**Subject: Access Logistics Park – 884-928 Mamre Road, Kemps Creek – Access Road**

In regard to the email you sent on 16 February 2023 with subject "Access Logistics Park - Meeting Minutes for the 08.02.2023", we have outlined below our responses to the actions and comments made by TfNSW.

Attachment 5 – Updated LILO Plans

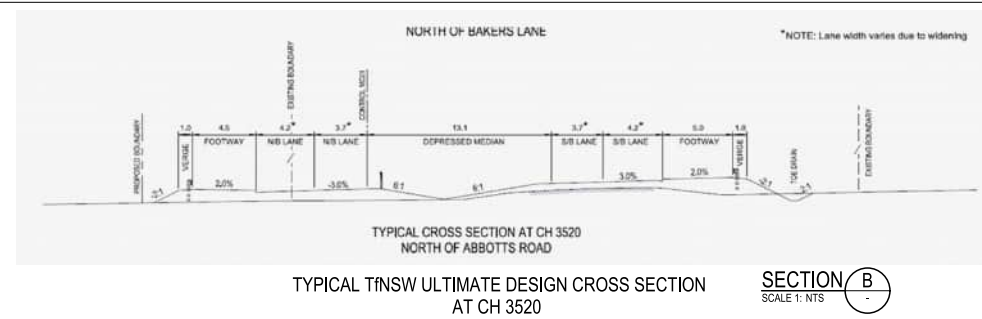
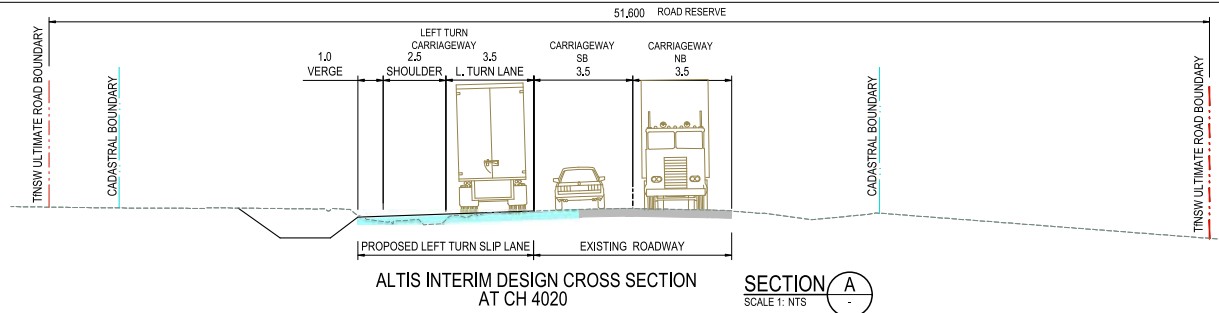
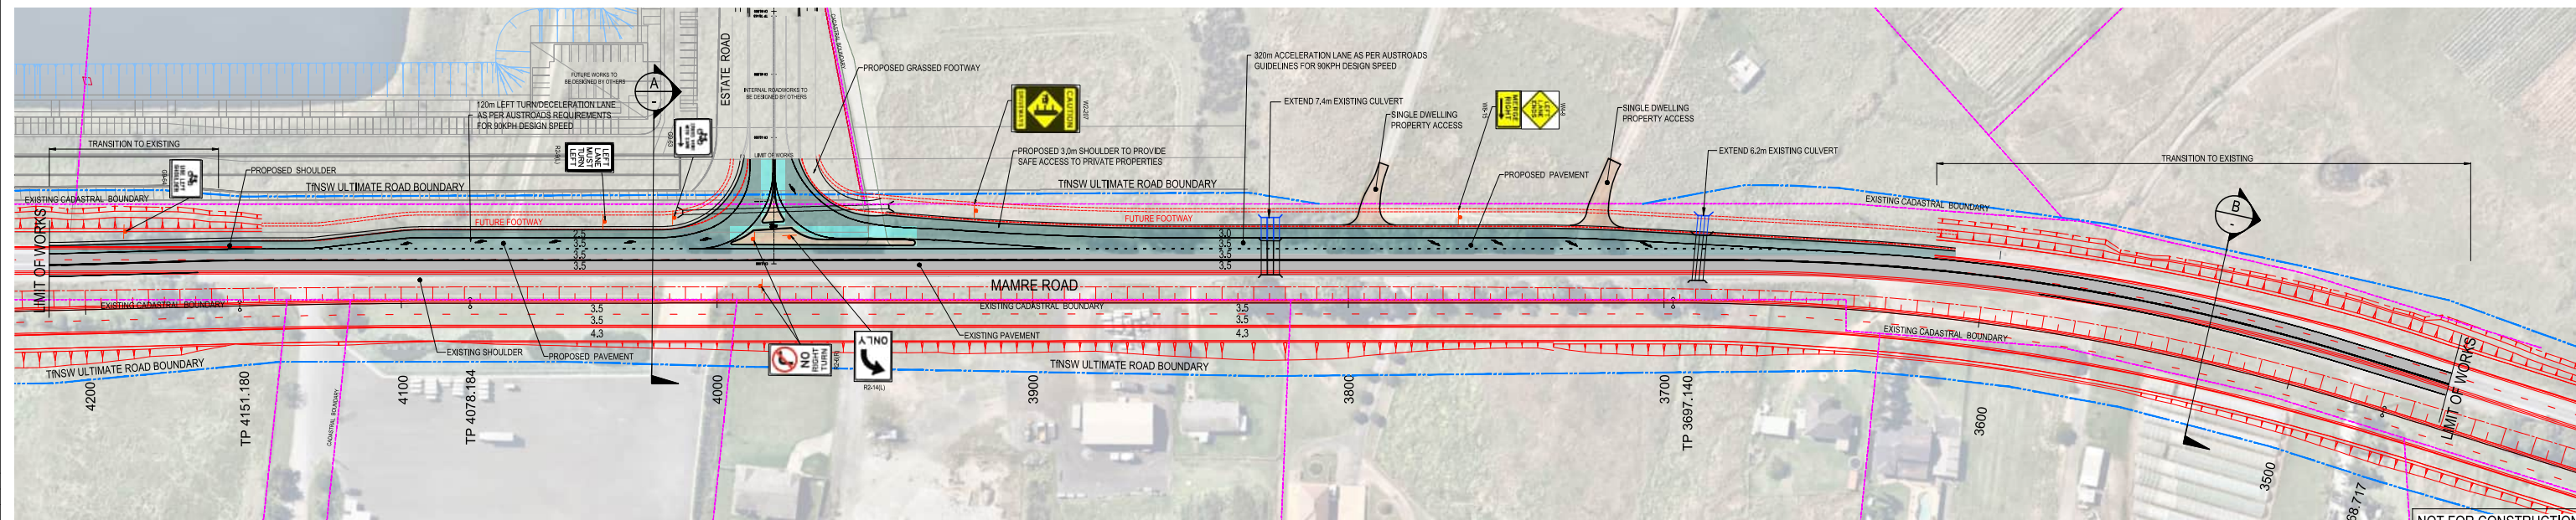
1. Permanent LILO:
  - a. TfNSW (JD and PR) requires the acceleration lane be removed and a simple left turn be installed onto Mamre Road. The redesigned LILO (as above) and deceleration lane must comply with Austroads guidelines for a 90km/h speed limit TfNSW with design details provided to demonstrate compliance.

- b. TfNSW (JD) The retention of the existing driveway accesses with the 3m shoulder adjoining the deceleration lane extends across land that is not under the ownership of the Applicant or included within the current Development Application. As identified above the 3m shoulder and acceleration should be removed. Once the affected lots are developed TfNSW may consider the acceleration lane as a post development process.

4. Identification of additional land adjoining the deceleration lane for future road upgrades.
- a. Action (Applicant): The Applicant is advised to identify and provide revised plans that detail the available land for future road widening (3.5m shoulder). The plan set should include a long and wide section demonstrating the potential for future land dedication.

5. The deceleration lane and subsequent land dedication for future widening in accordance with TfNSW policy please provide an amended drawing displaying that the land is available for future upgrade

MRUS2 Project Team Comments	MU Group (Designer) Responses
Crossing point for pedestrians / cyclists on access road to consider safety (e.g. line of sight)	A pedestrian/cyclist crossing that complies with Austroads and TfNSW technical directions has been added (refer to 2021_19_SD_0001_SK00014 Issue B). The crossing point is 50m from the intersection, which provides sufficient line of sight, and is compliant with Austroads Part 3 horizontal stopping site distance of 20m (Figure 5.4) with an additional 26m B-double length. This allows the stopping site distance to the back of a 26m B-Double waiting at the pedestrian crossing. This plan is contained within Annexure 1
Extension of culverts to align with capacity requirements from Sydney Water. Also extend culverts to the west, to allow for safety of workers when constructing median / northbound lanes	Please refer to detailed response in comment 3a.

The strategic design drawing (2021\_19\_SD\_0001\_SK00014 Issue B) shows a simple Left-In-Left-Out design without the acceleration lane as advised by TfNSW. This plan is provided in Annexure 1.

With reference to Table 5.2 in Austroads Guide to Road Design Part 4A (see below), for a design speed of 90km/h and a design speed exit curve of 20km/h, the length of the deceleration lane (D) is required to be 120m (most conservative). **The strategic design issued to TfNSW has a deceleration lane length of 120m, which is compliant with Austroads requirements.**

It should be noted that there are no existing driveways to be retained adjoining the proposed deceleration lane. The proposed design has a 2.5m shoulder adjoining the deceleration lane, which is wholly within the current road reserve (refer to drawing 2021\_19\_SD\_0001\_SK00014 Issue B) contained in Annexure 1.

We assume that this comment relates to the acceleration lane. The proposed design (2021\_19\_SD\_0001\_SK00014 Issue B) shows the acceleration lane and adjoining 3m shoulder have been removed.

The strategic design drawing (*2021\_19\_SD\_0001\_SK00014 Issue B*) shows in plan and cross section the available land for future widening. The proposed design shows a proposed 2.5m shoulder adjacent to the deceleration lane with a 1.0m verge and the remaining 12.3m available land to the ultimate road boundary.

The strategic design drawing (*2021\_19\_SD\_0001\_SK00014 Issue B*) shows in plan and cross section the available land for future widening. The proposed design shows a proposed 2.5m shoulder adjacent to the deceleration lane with a 1.0m verge and the remaining 12.3m available land to the ultimate road boundary. This plan is provided in Annexure 1
